## FW: SUB19-002 (SEP19-005/Requirement For No Onsite Open Space/Lack of Tree Regulation

Specifically his claim that a long plat that is regulated by both MICC 19.08 et seq and R.C.W. 58.17.020 does not require any onsite open space:

**"Staff Finding: The proposed development makes a provision for open spaces in the form of a private easement for passive open space (Exhibit 5). The MICC does not provide a numerical standard with respect to the level of appropriateness as to the provision of open space".**

JOB NO : 19007
SHEET 3 OF 3

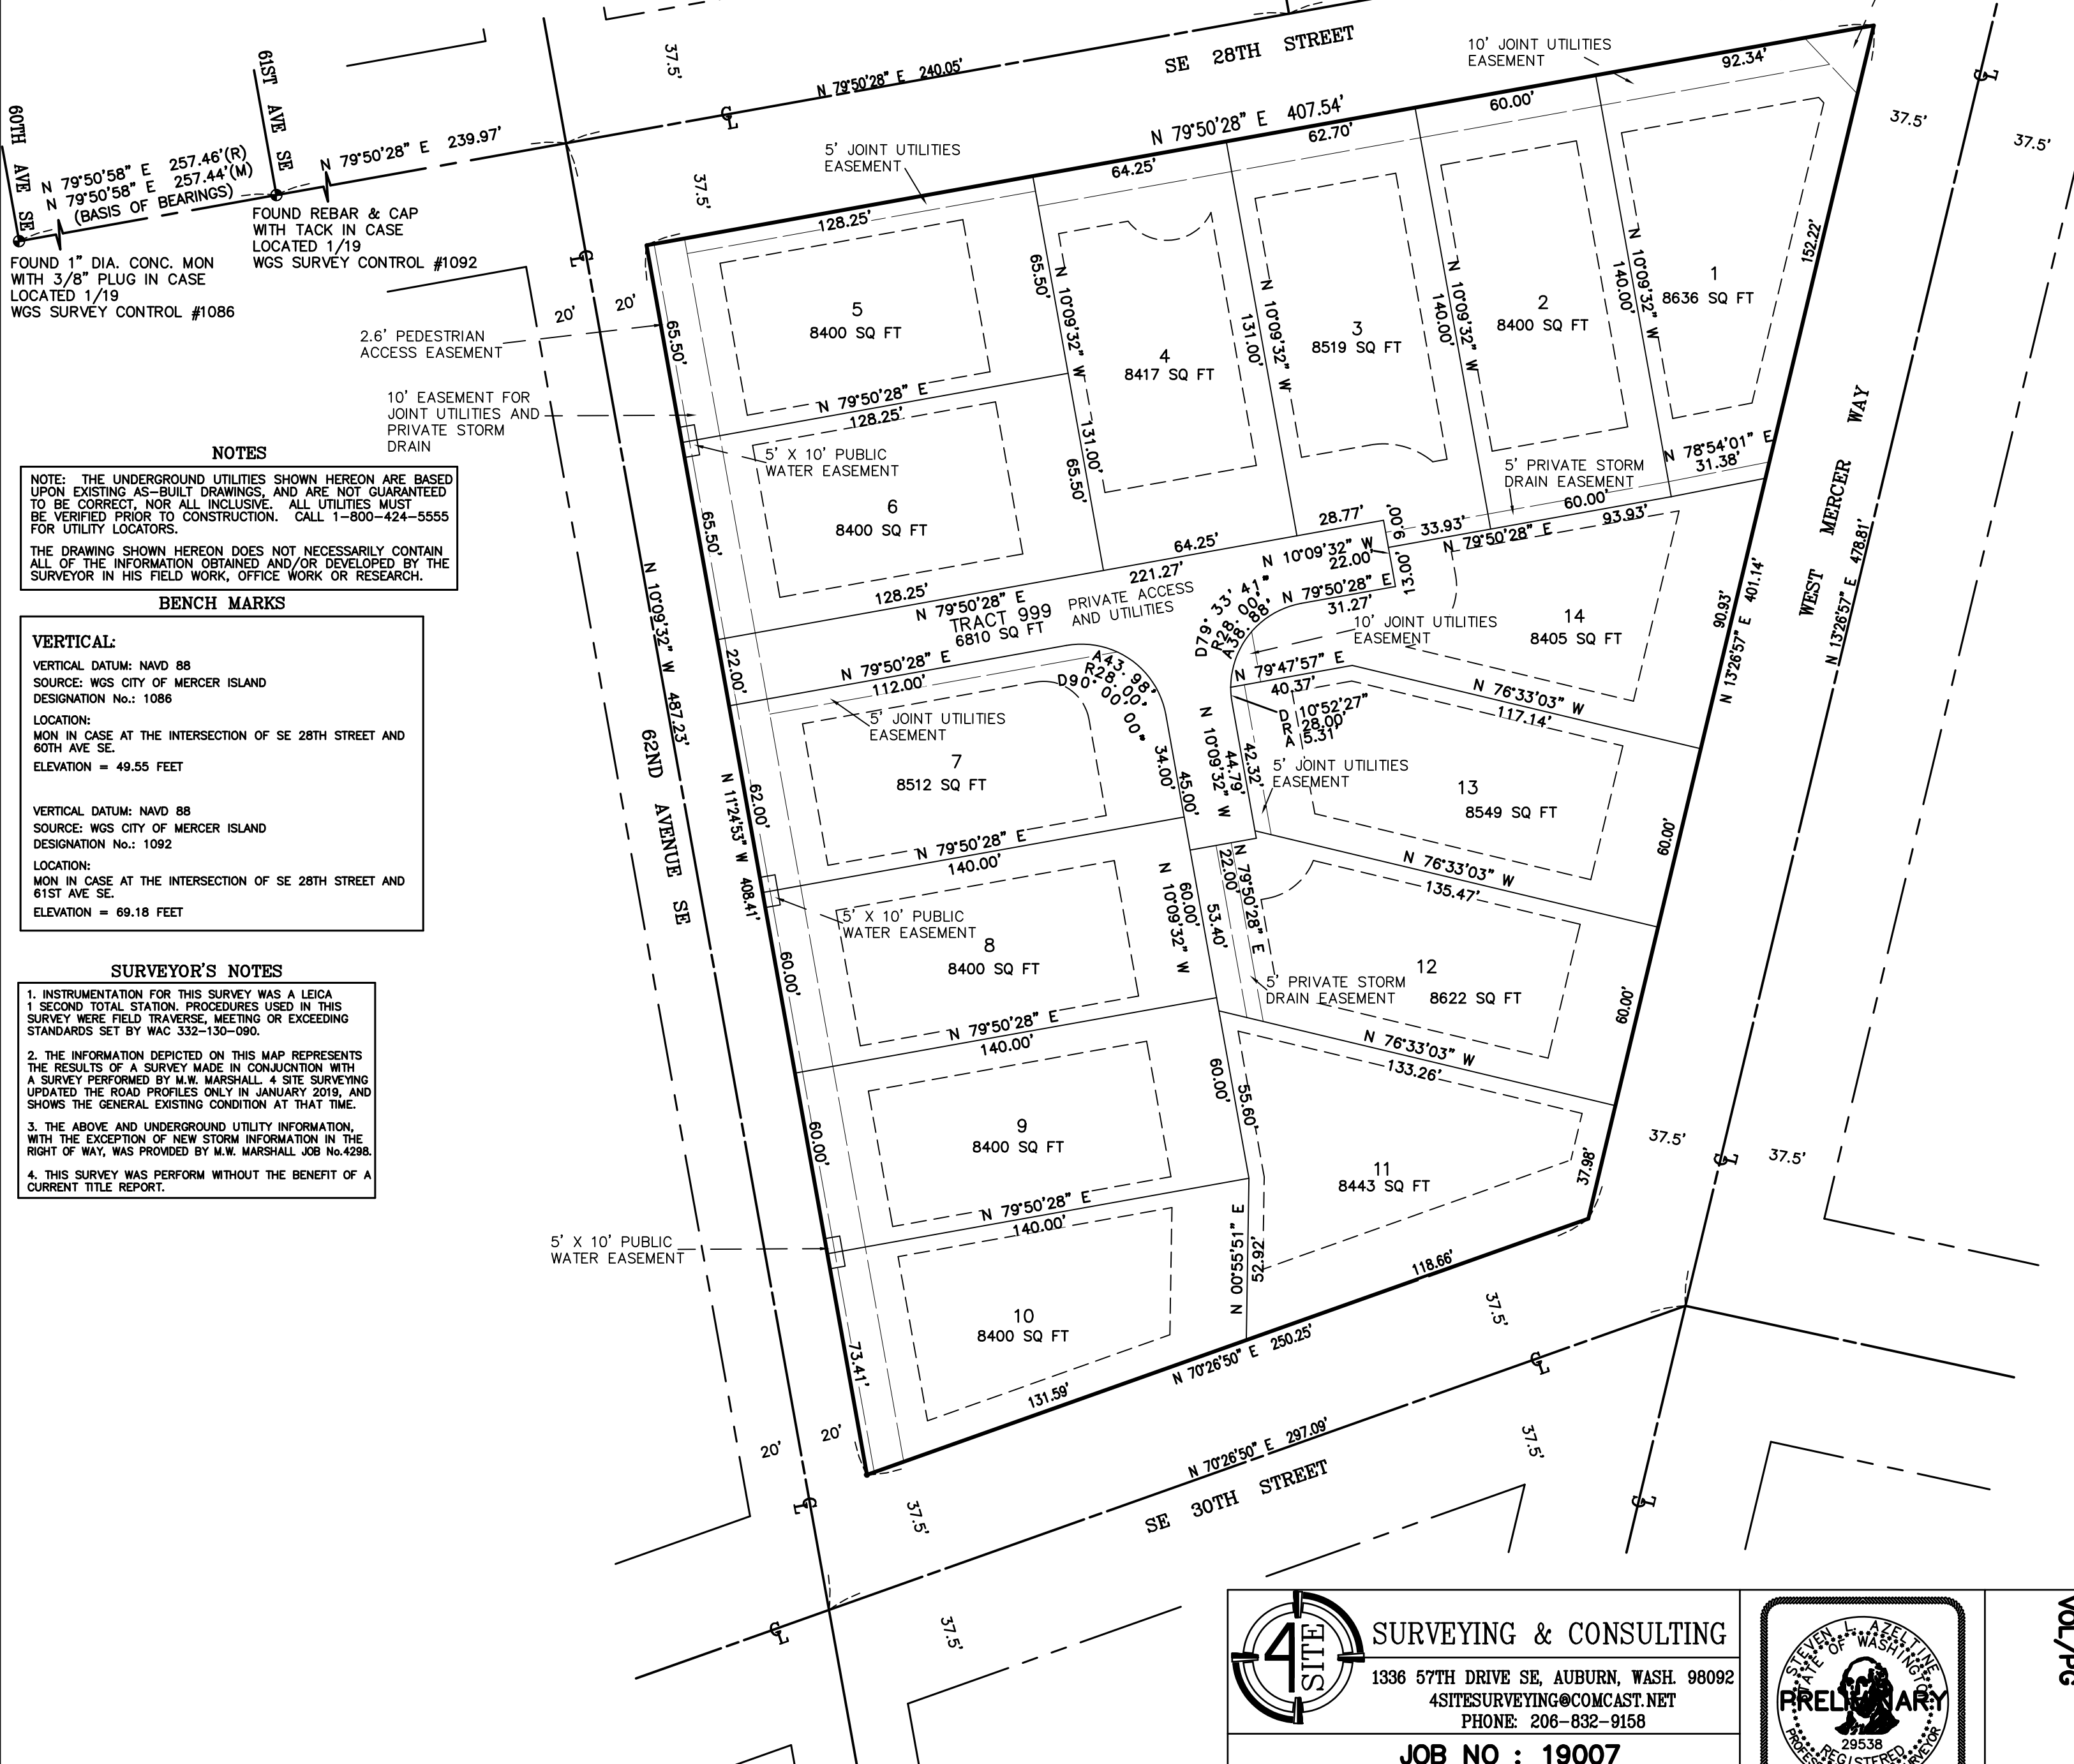
Here is a site map for the proposed 14 plat long division. [12. pin2174502425-supplplatmap.pdf \(mercergov.org\)](#). The only "open space easement" listed on the map is the tiny triangle in the upper right-hand corner.

SITE PLAN
2825 W MERCER WAY
PRELIMINARY PLAN
PARCEL #2174502425
CITY OF MERCER ISLAND WASHINGTON

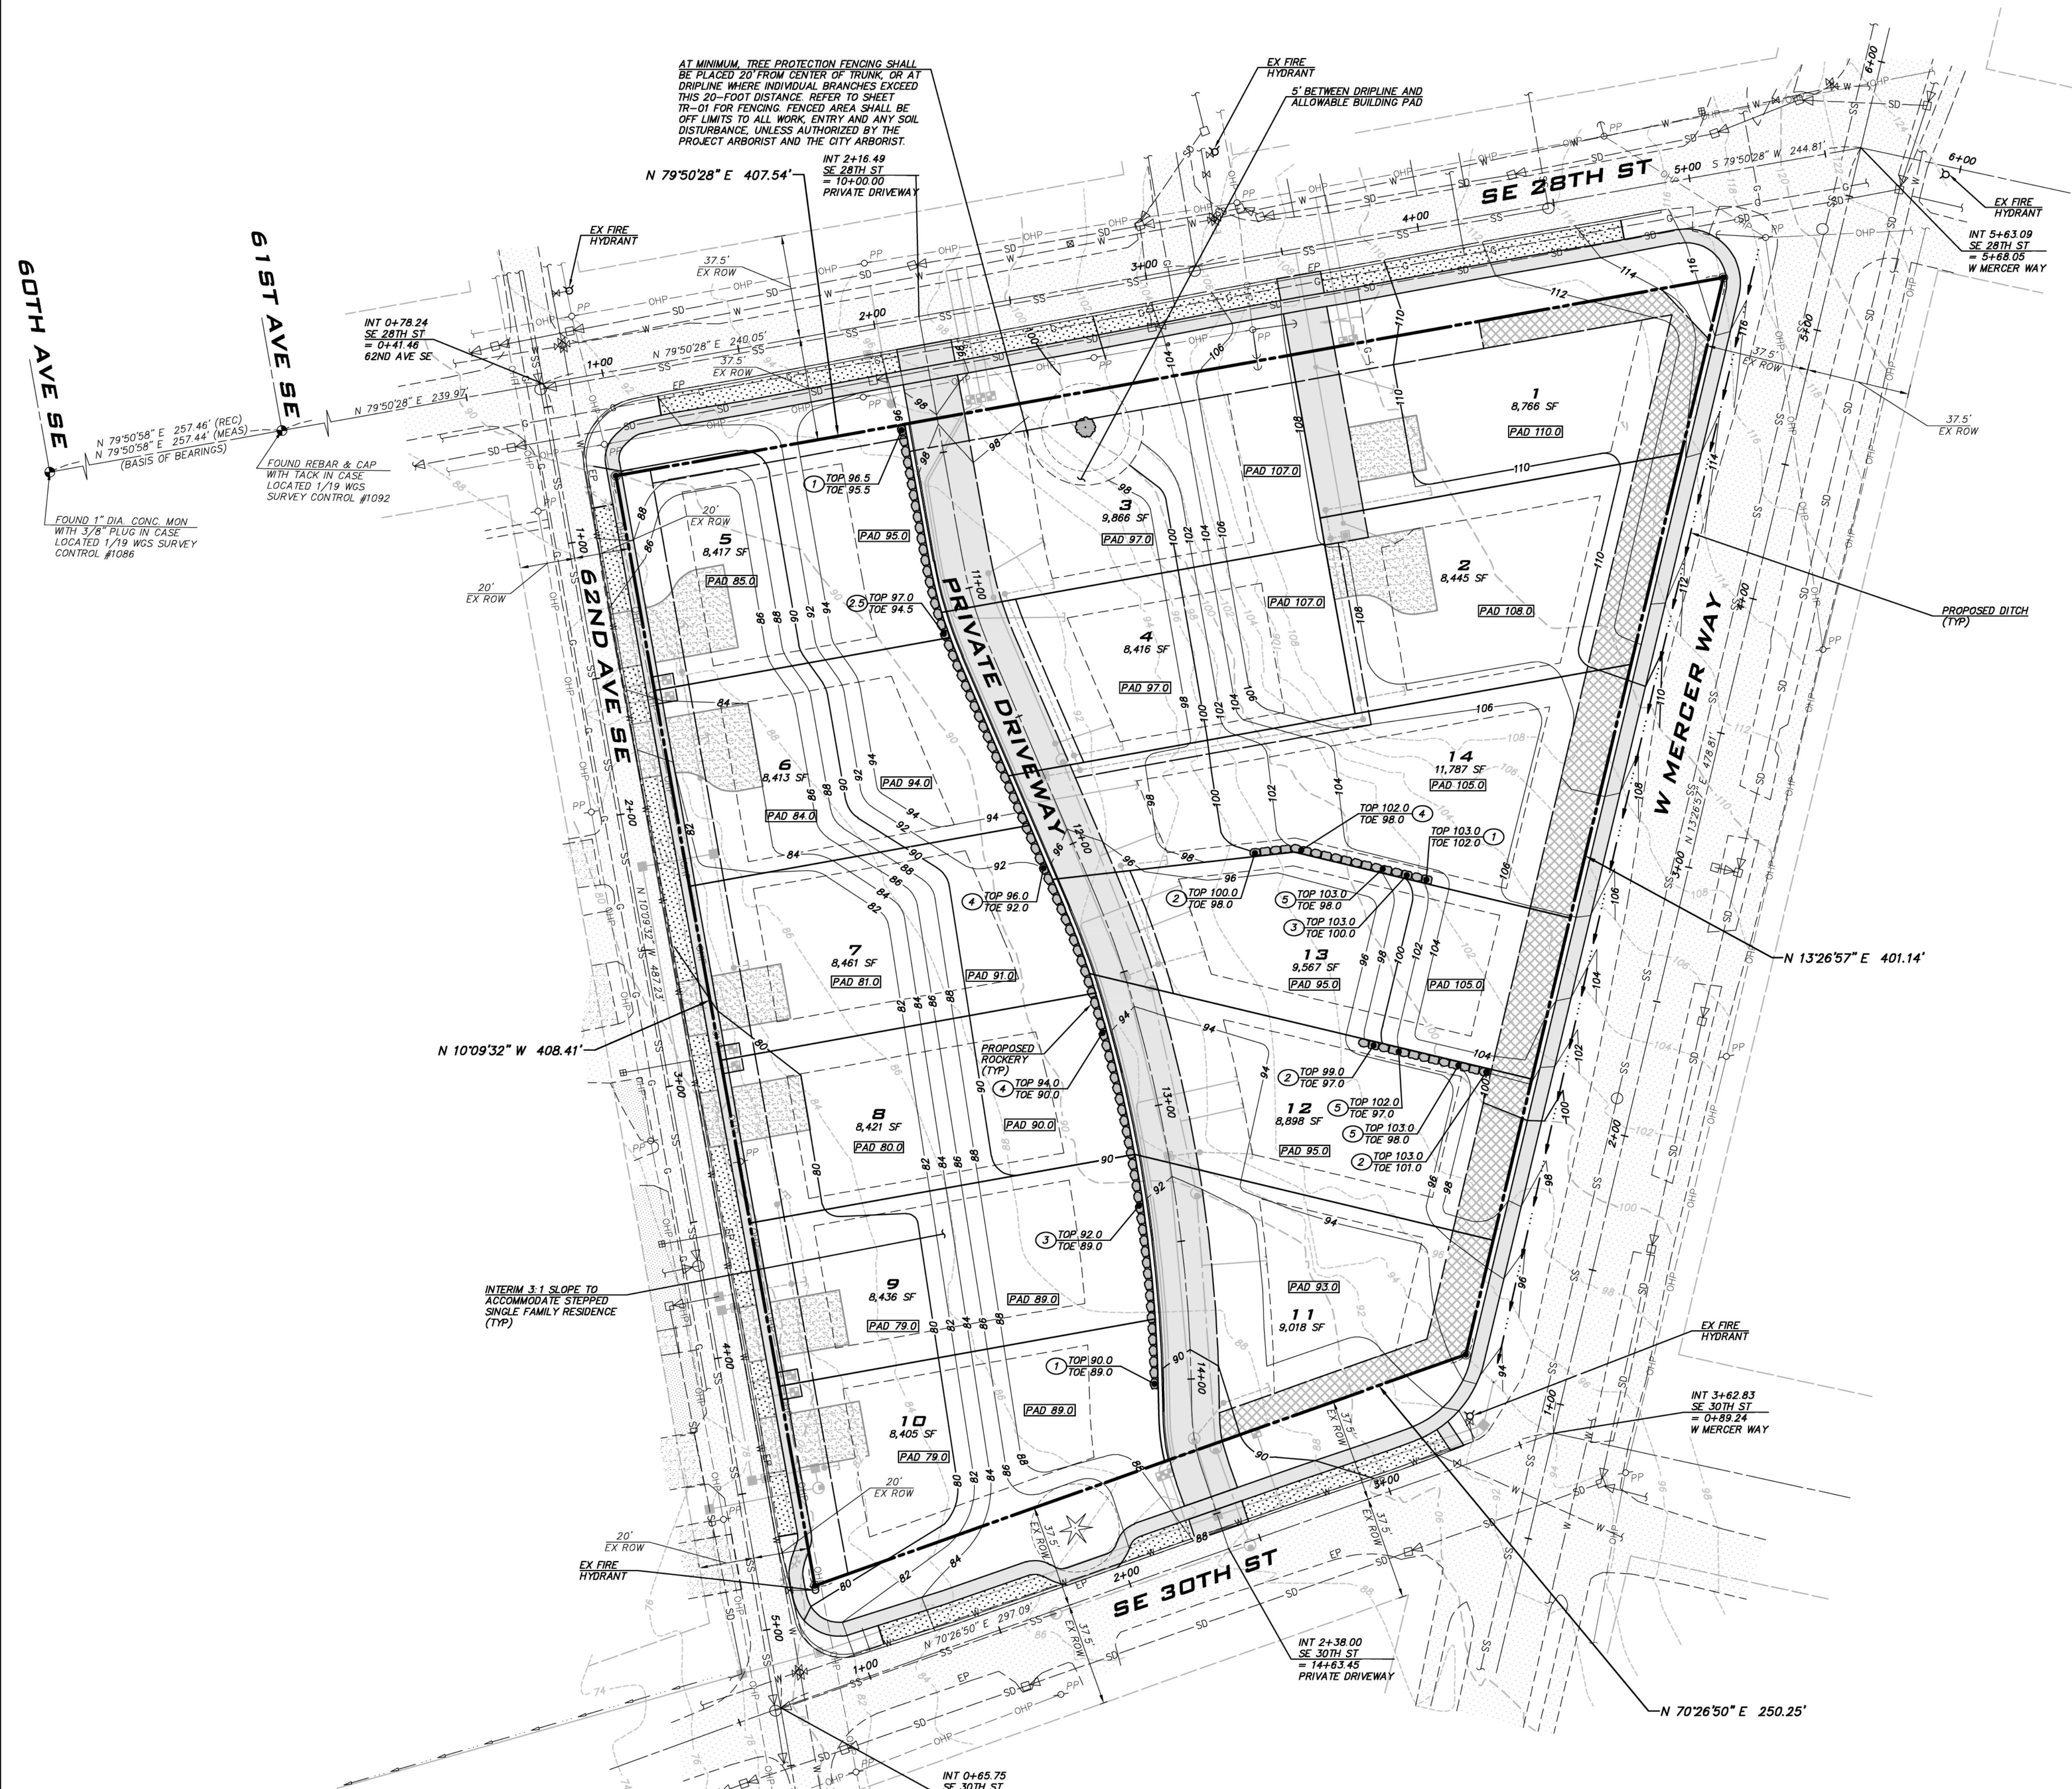
**"Staff Finding: By providing walking access along the West Mercer Way frontage to the Secret Park, the Applicant provides access to existing open space and recreation facilities sufficient to serve the proposed subdivision".**

- A. There was no internal access road so all 14 lots had access drives directly onto the street.
- B. There was no meaningful open space available to the public, especially for a parcel that was originally donated to the BGC by the MI School Dist. to remain open and recreational space, and by the purchaser who claimed that was his intent but lied.

The KEY is the internal access road is lot area that is deducted from the total lot area available for lots, AND so is the open space. Under the original plan Evan Maxim demanded there could only be 13 lots because there would be an internal access road, AND meaningful open space for the public. The way the applicant in the most recent design adds an access road and still can achieve 14 lots is by eliminating one of the most important requirements of the MI code and state statute: open space available to the public, on a parcel that was designed to be entirely open space in perpetuity.

NO	DATE	BY	REVISIONS
1	10/12/22	AWK	REVISION PER CITY COMMENTS
2	10/12/22	AWK	REVISION PER CITY COMMENTS

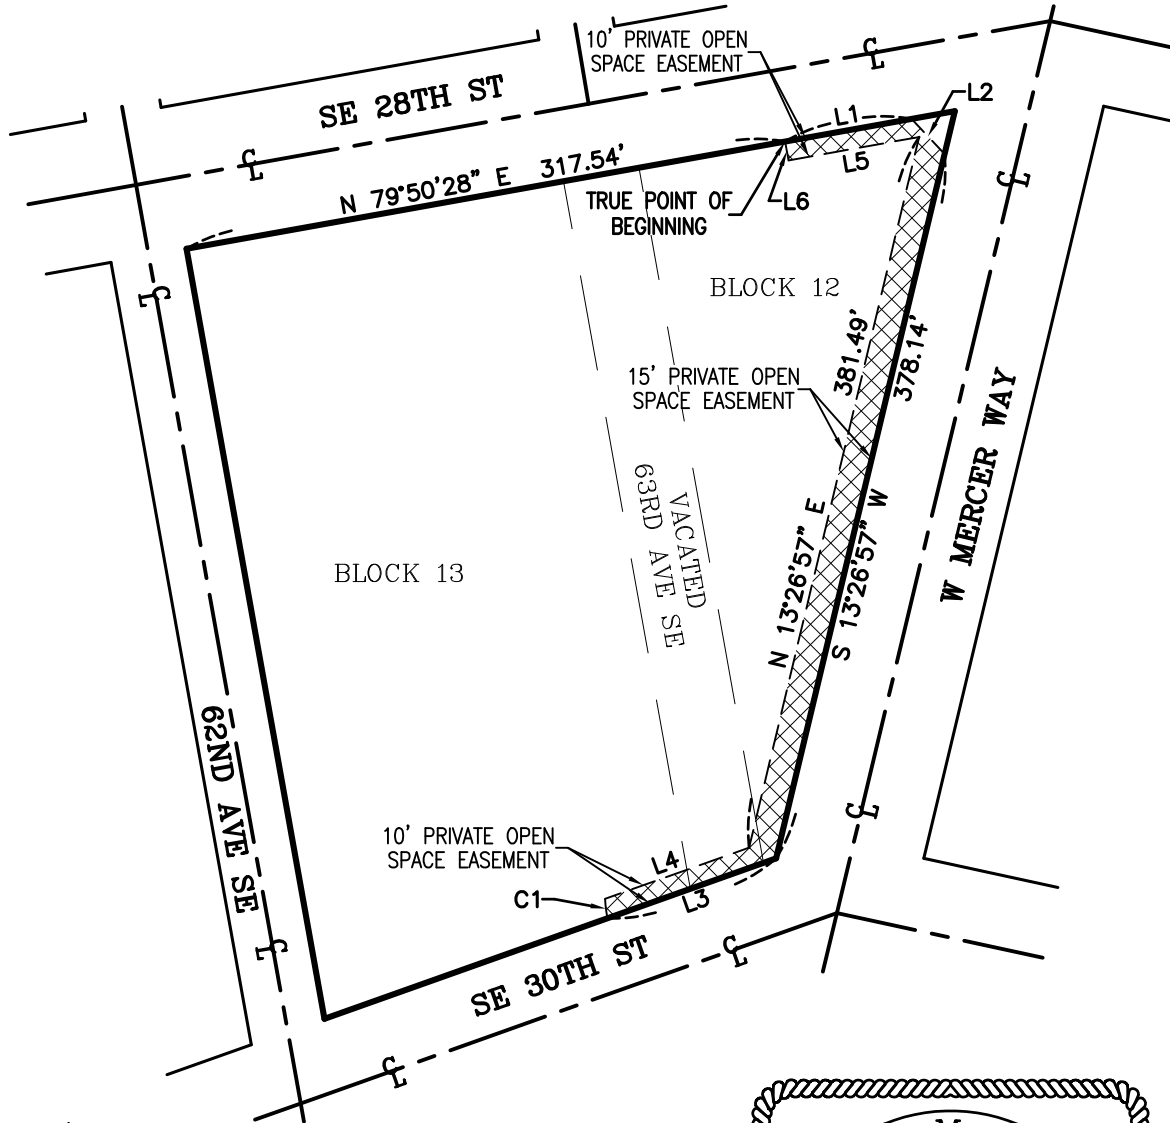
"2. I also think the city planner made a significant mistake. The "open space" is not for the benefit of the subdivision owners – hence the "path" along WMW to the secret park which is really an insult – the open space must be onsite and for the benefit of the entire public, especially the surrounding neighborhood. This is even more important for this property because of the owner's prior promises, and his own comments in 2008 that this part of the Island has little recreational or open space opportunities for kids. A path from the subdivision to secret park (which is quite small) for the benefit of the subdivision owners misses the entire point of the open space provision.

I have never heard of something so absurd. The applicant's "open space" is based on an existing city park accessed by the required setback. Because the planner claims that, *"The MICC does not provide a numerical standard with respect to the level of appropriateness as to the provision of open space"* the planner interprets this to mean zero open space without addressing the requirements under R.C.W. 58.17.020. **Is Jeff Thomas really rewriting state law and the MICC to hold a 14-lot long plat requires no onsite open space, or this is the intent of 19.08? Is Jeff unaware of the Coval long plat?**
